Kirklees Highways Development Management comments

2021/62/92086/W – Erection of 270 residential dwellings and associated infrastructure and access

Land at Bradley Villa Farm, Bradley Road, Bradley, Huddersfield, HD2 2JX

PROJECT NAME:			
PROJECT: BRADFORD ROAD HUDDERSFIELD			
TITLE: PROPOSED SITE SECTIONS			
SCALE & NO:	DESIGN DRAWING:	APPROVED:	DATE:
1:1000 & 1:250	RE	CP	29.03.21
PROJECT NO:	DRAWING NO:	REV:	
BVF	BVF-16-02-07	A

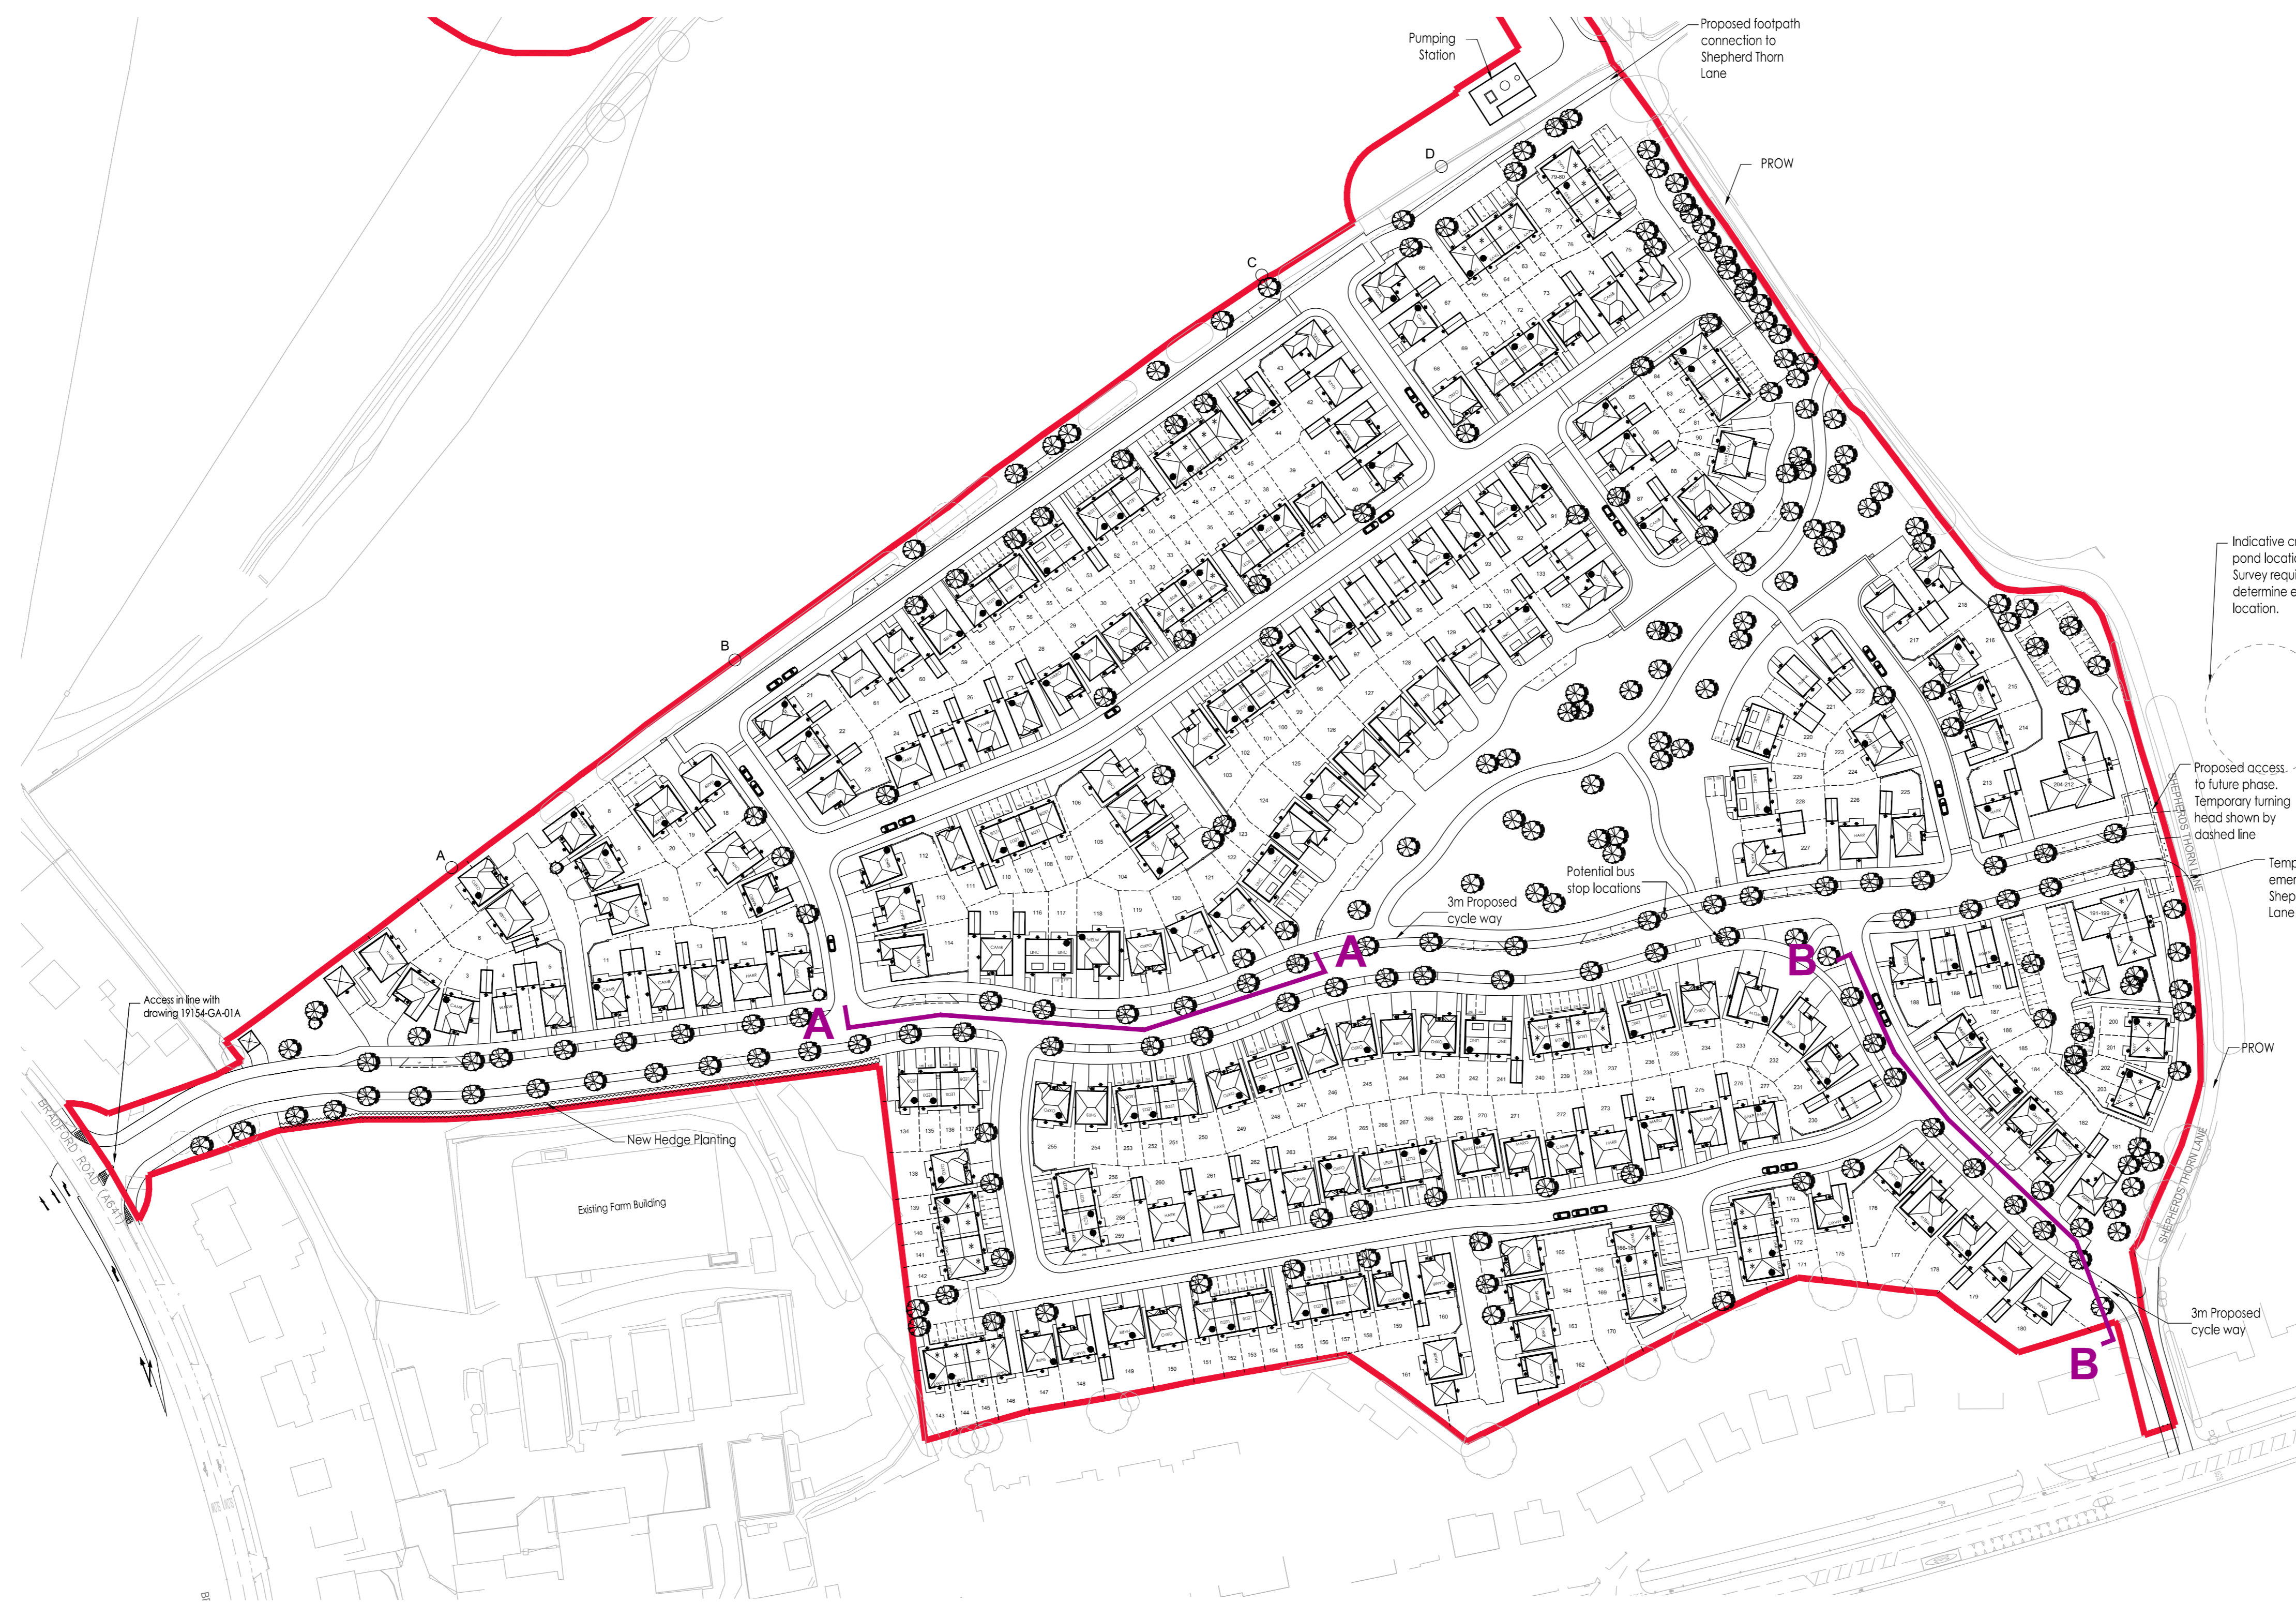
xxiv. With regards to the vertical design of the proposed roads, the following needs to be complied with:-

- Given the significant level differences, roads with intermittent 1:10 longitudinal gradients can be considered for adoption. A road with 1:10 gradient throughout would not be acceptable as it prejudices against users with disabilities.
- At internal junctions 15m from the tie-in to the main road channel will need to have a maximum gradient of 1:25 to avoid grounding issues for vehicular users;
- While proposing longitudinal gradients it must be noted that given the above gradients up to 5% (1:20) are generally considered acceptable for pedestrians, including wheelchair users. Gradients over 2.5% (1:40) might be impassable for

- i. For a full application site contours, plot finished floor levels and proposed road contours/road long sections are necessary for officers' full assessment. Complete information was not made available on this occasion;
